CITY OF PORTLAND
HOUSING SAFETY OFFICE

Inspection Violations

Owner/Manager MATHEW'S APARTMENTS INC		Inspector Matthew Sarapas	Inspection Date 1/16/2018
Location 10 GRANT ST	CBL 036 E008001	Status Follow up Required	Inspection Type Legalize Nonconforming units

2ND FLOOR  
106 GRANT ST.  
PORTLAND MAINE

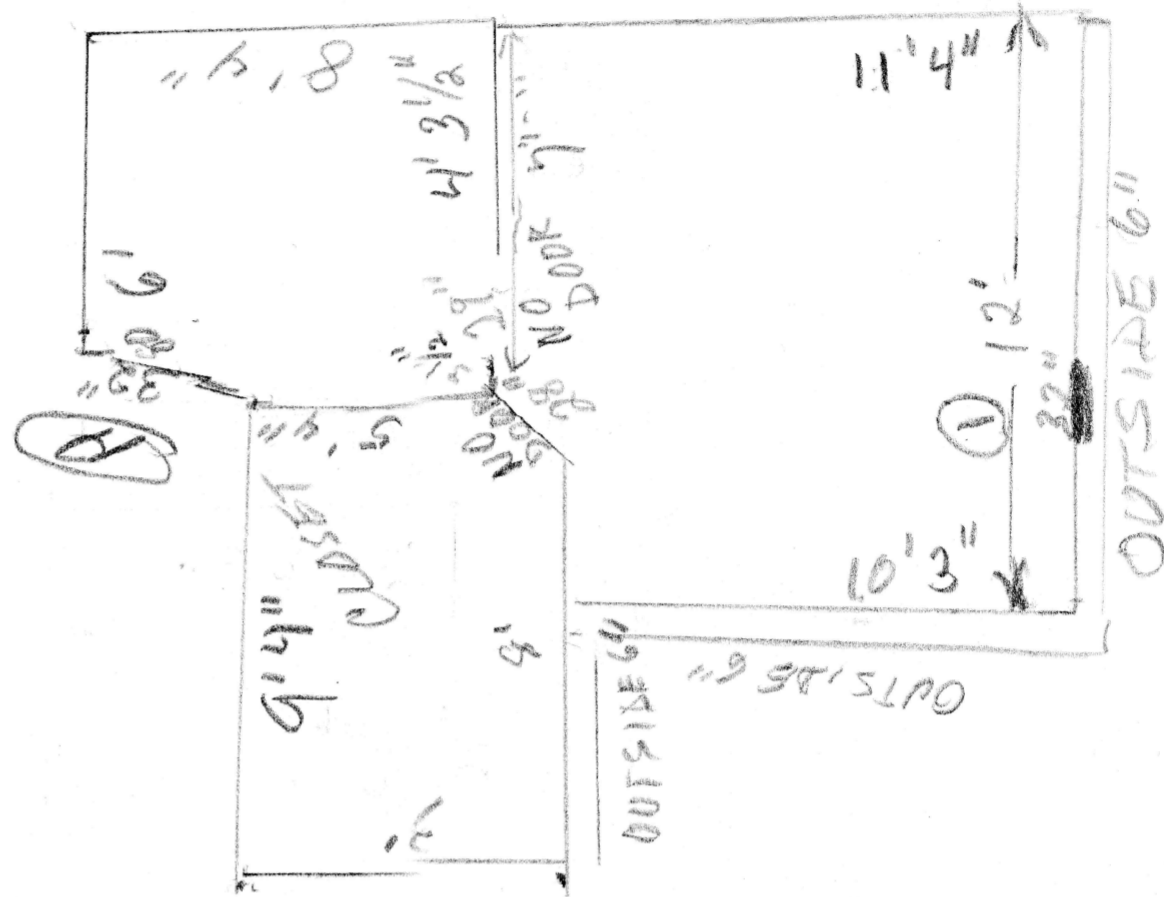
Notes: Nothing can be stored in egress stairs, remove stored items in hallways front and rear. Storage area outside second floor of #10 must be rearranged so that door can be closed.

Notes: Tenant in second floor of #10 has repeatedly removed smoke alarm in living room, smoke alarm tampering is punishable by a fine assessed on tenant of up to \$500 per alarm removed.

Notes: Dryer in second floor of #10 must be vented properly through an exterior wall with solid metal pipe or removed.
